**Subject:** RE: F/2/25/PL - Newhouse Farm Barns

I have just been checking in on our application and I have responded below to comments from Private Sector Housing team (attached)

THE MILL STUDIO, FORD BN18 0EF
STUDIOS 1 & 2: PROPOSED

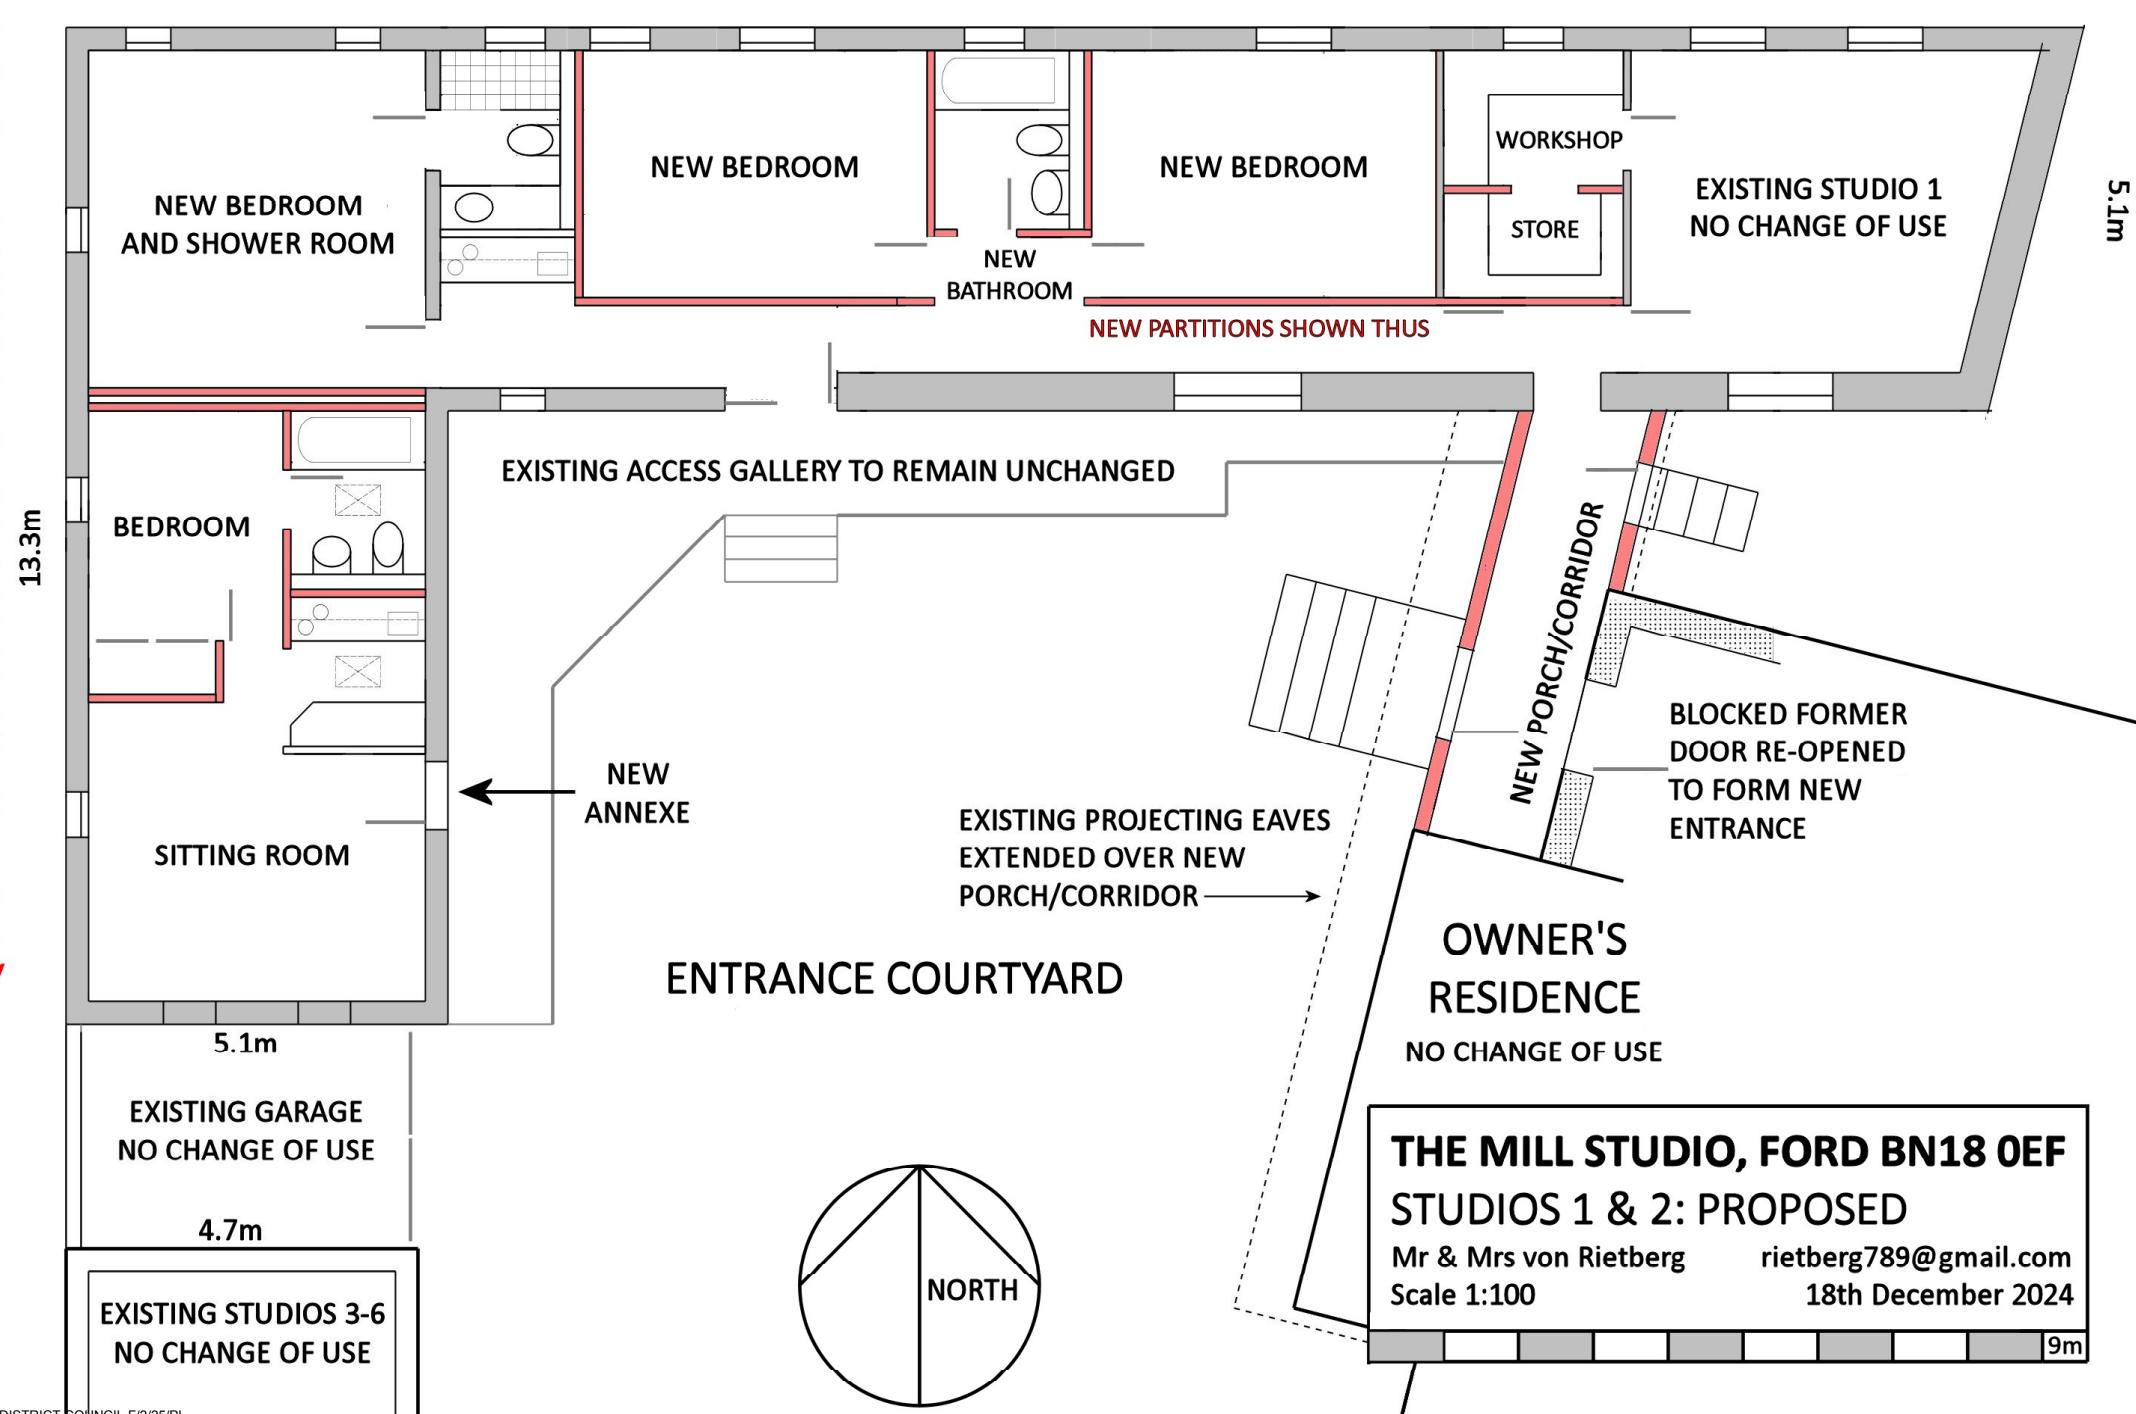
3. Mini-kitchens:

- a. Studio 2: this is not a 'cooking' facility, only an early morning tea/coffee station, with electric kettle and sink, to avoid a long walk to the existing kitchen in the main dwelling. Please see amended drawing attached.
- b. Annexe: the windows to sitting room and bedroom will be fully opening as means-of-escape. Kitchen is on this side to facilitate services connections.

STUDIOS 1 - 6: ELEVATIONS

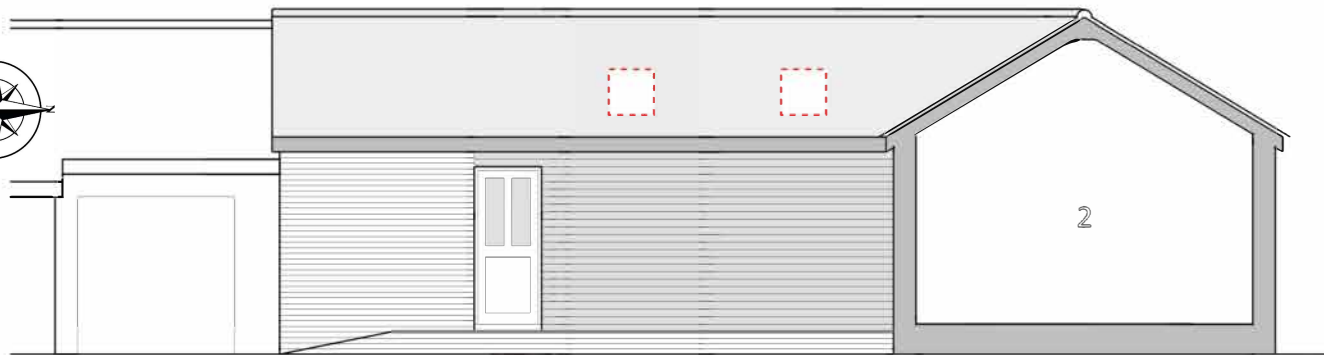
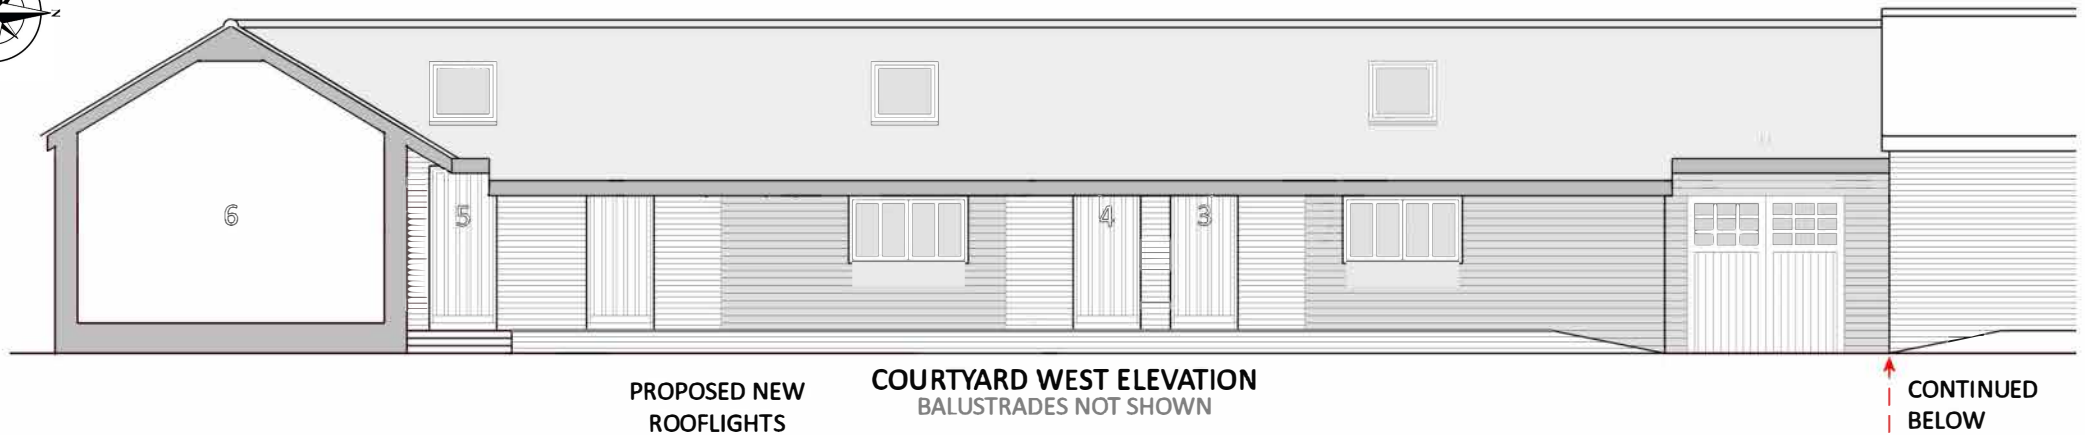
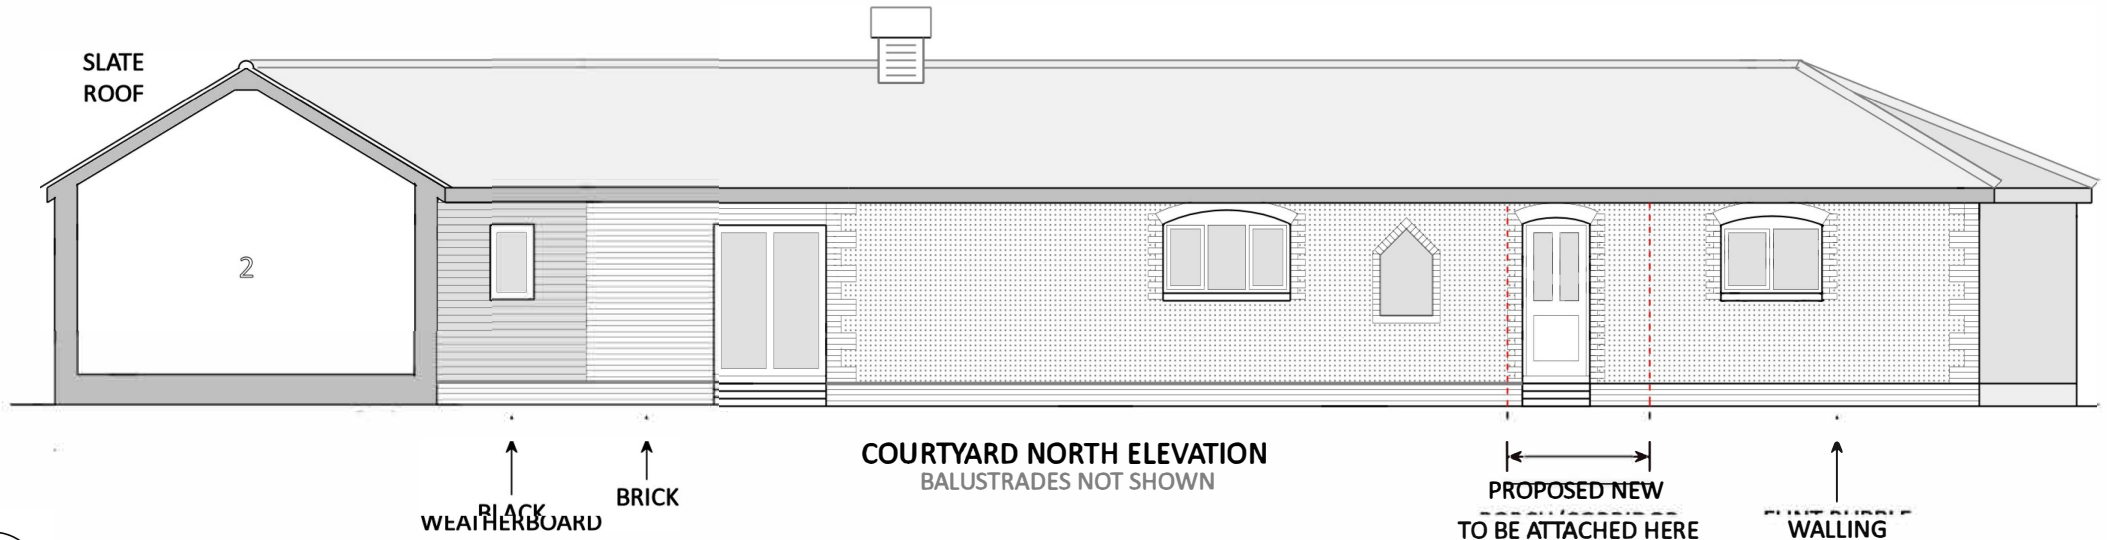
5. An opening rooflight will be installed over the Annexe bathroom, as shown on ELEVATIONS drawing.
